Subdivision Comments

From: Holly Erdman, Environmental Health Specialist

Date: 11/05/21

RE: LP-21-00003 Stanavich

STANAVICH AG PLAT  
PART OF SECTION 35, T. 19 N., R. 18 E., W.M.  
KITITAS COUNTY, WASHINGTON  
- PRELIMINARY PLAT -

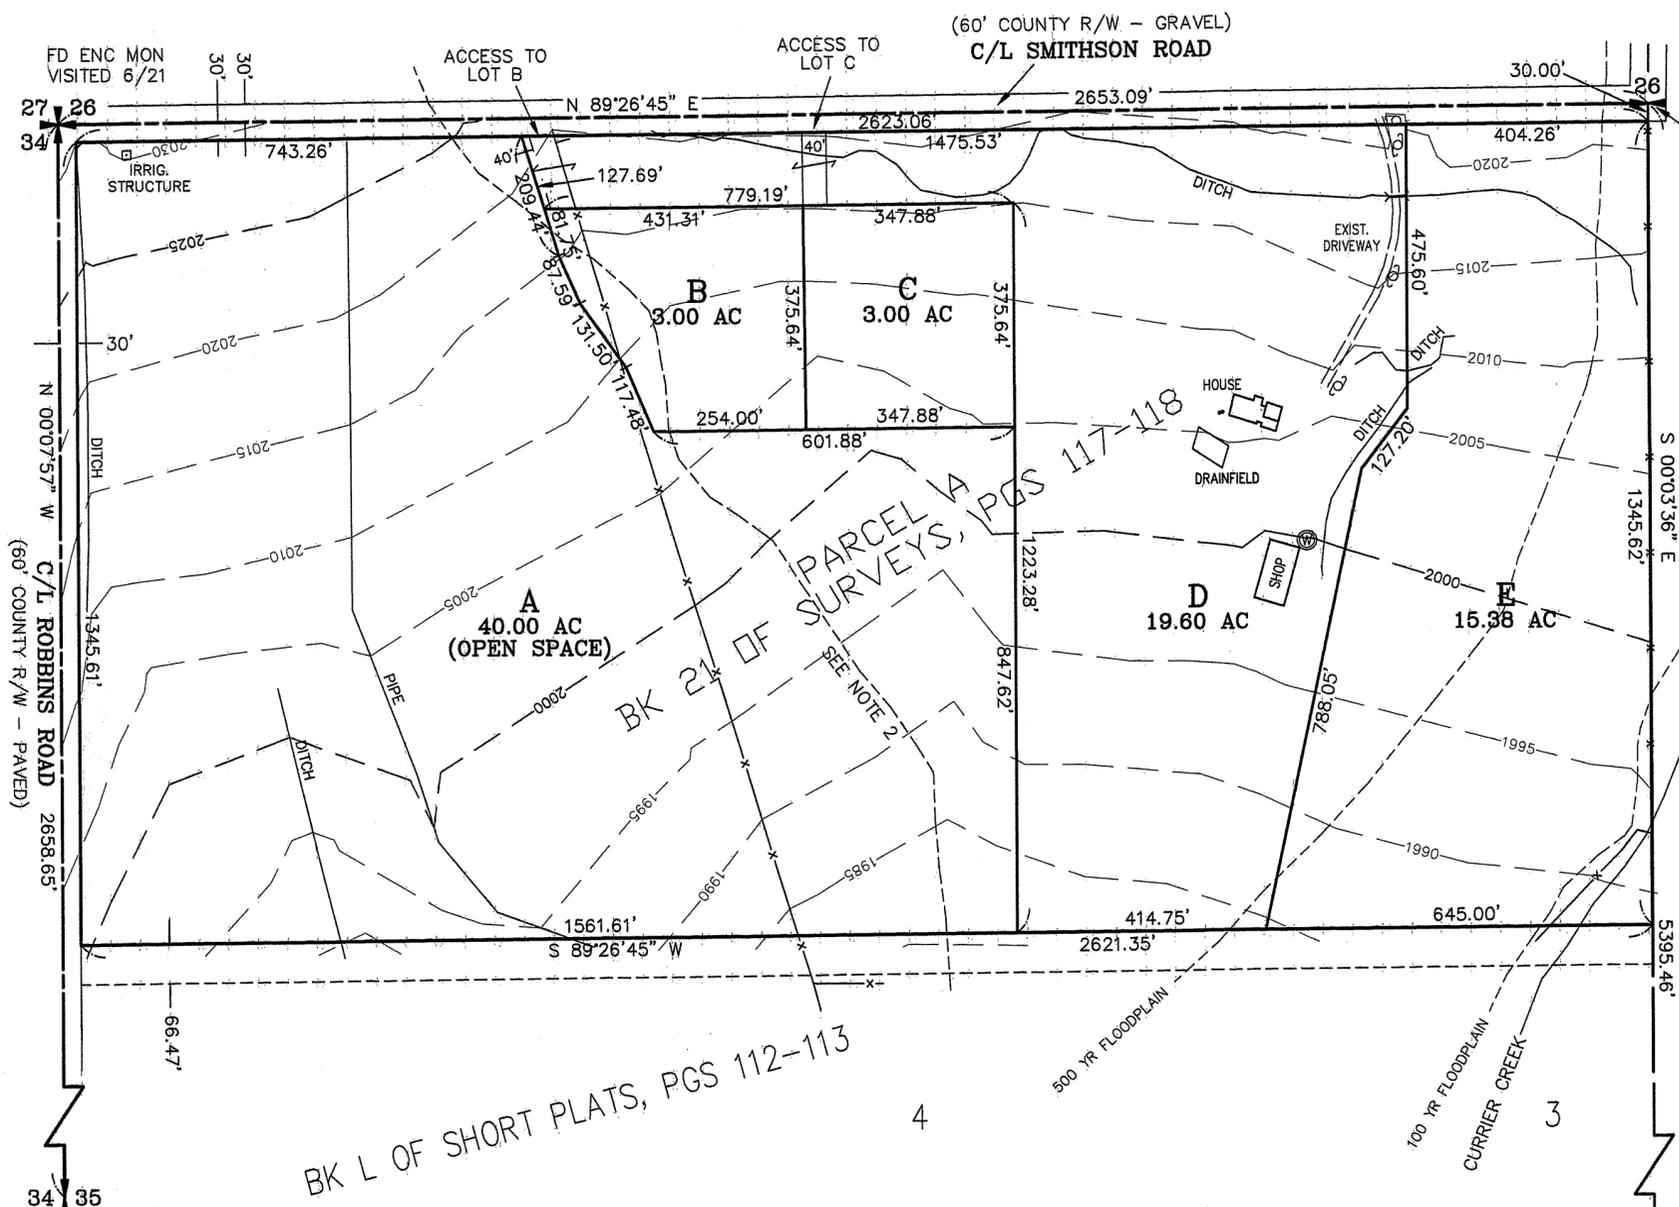
Proposed long plat indicates a combination of shared wells or individual water systems will be used. The applicant must prove legal and physical availability of water for all new uses of water on proposed lots.

With the exception of lot D, please provide one soil log for each new, proposed lot.

Where individual wells are proposed, a well log must be provided along with documentation of water rights for each proposed new lot. Where shared wells are proposed a well log, water right documentation for each lot and a shared well user's agreement must be signed, notarized and filed.
